APPLICATION BY NATIONAL GRID ELECTRICITY TRANSMISSION

**FOR AN ORDER GRANTING DEVELOPMENT CONSENT
FOR THE SEA LINK PROJECT**

(REF: EN020026)

**DEADLINE 6: PORT OF LONDON
AUTHORITY'S COMMENTS ON SUBMISSIONS
RECEIVED AT DEADLINE 5**

Plate 1.1 Areas of Safeguarded Water Depth

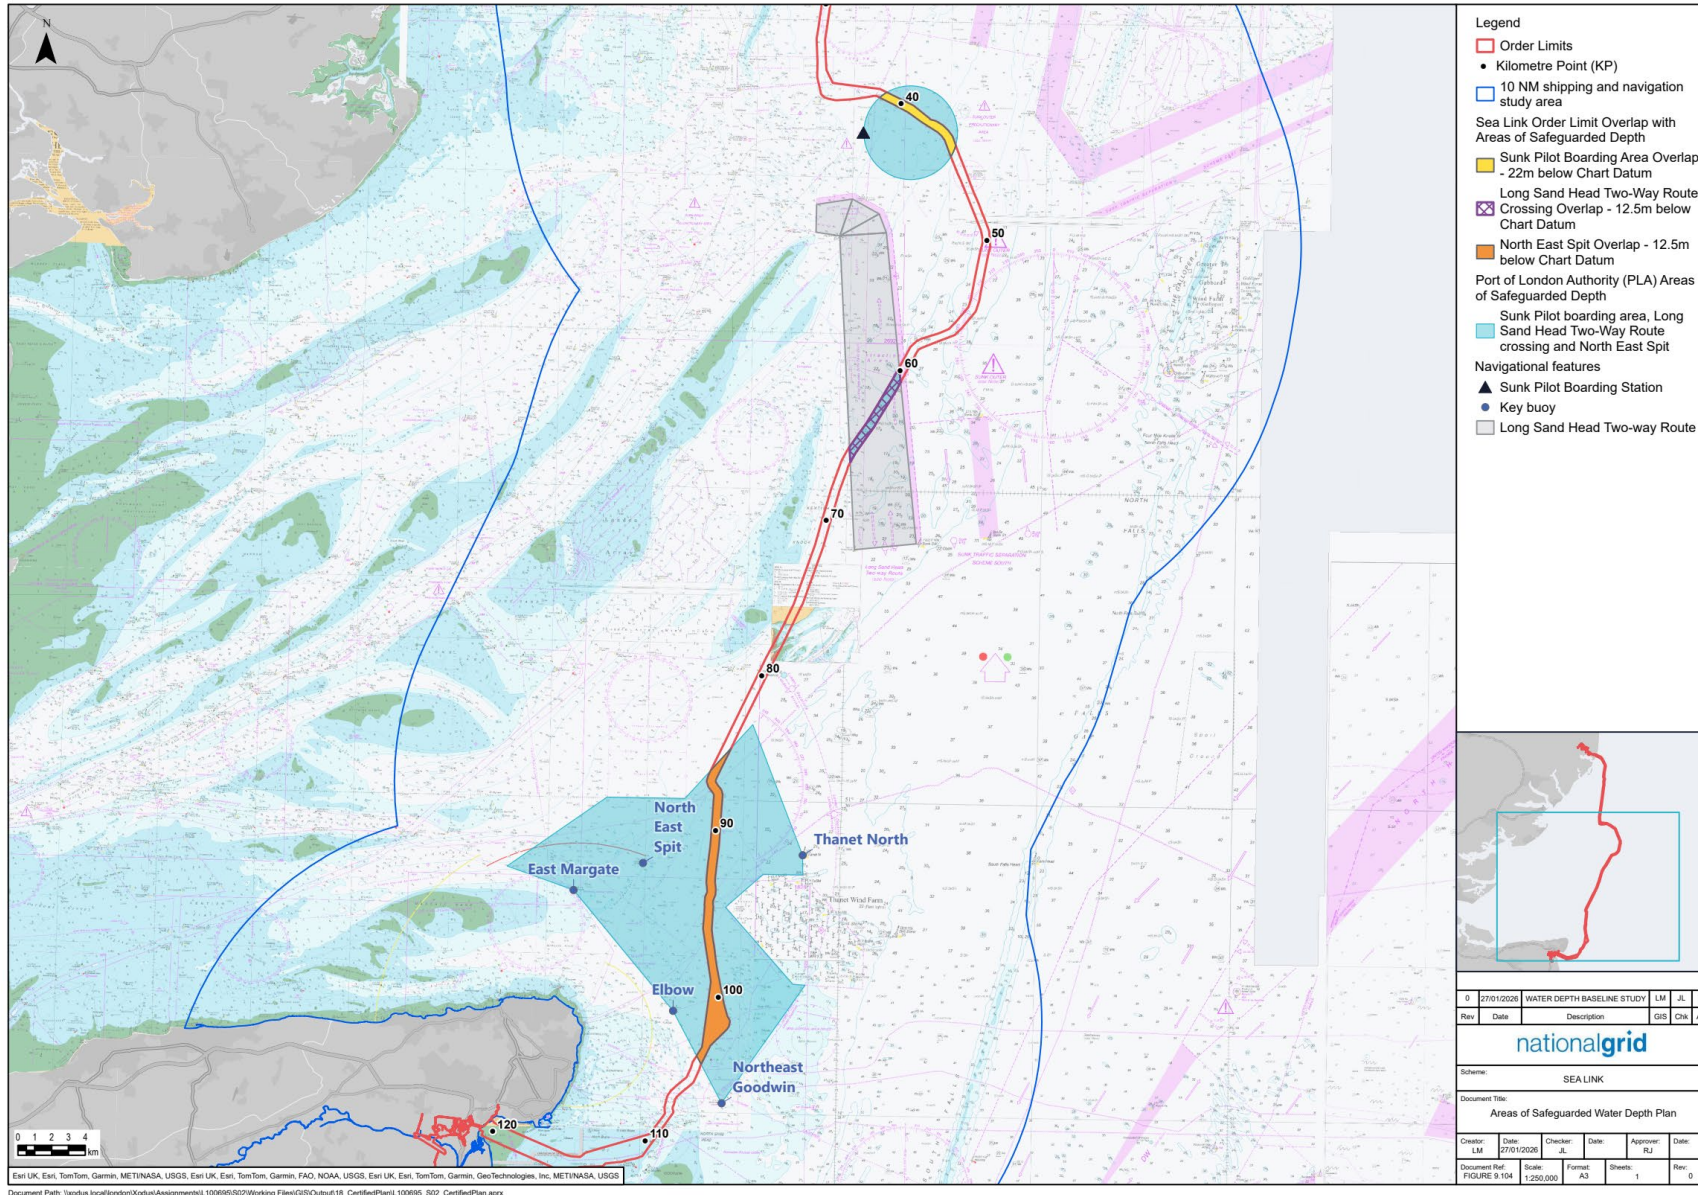
- 12.1 The PLA welcomes the production of this Report which advises that further engineering work has been completed to establish the most appropriate method of installation for achieving the required Safeguard Water Depths. This relates to additional pre-sweeping requirements in the Sunk Pilot Boarding Area and the use of additional cable burial techniques within the NE Spit area.

- 12.2 The Report identifies that at the Sunk Pilot Boarding Area pre-sweeping will also be required between KP38.7 and KP44.4 at an average depth of 1.5m with the material being re-distributed within the pre-swept area of the Order Limits This is in addition to the previously assessed application parameters of pre-sweeping KP96.32 to KP113.883 at an average depth of 2m.
- 12.3 At the North East Spit the creation of a trench by backhoe is the preferred option between KP102.4 to KP104.4.
- 12.4 The Applicant has confirmed to the PLA that this additional pre-sweeping means that the subsequent cable lowering “*remains 2.0m-2.5m below 22.5m CD*”. As a result of this confirmation, the PLA is content that the DoL information in the oCSIP and CBRA are consistent and that application documents do not require an update in respect of DoL
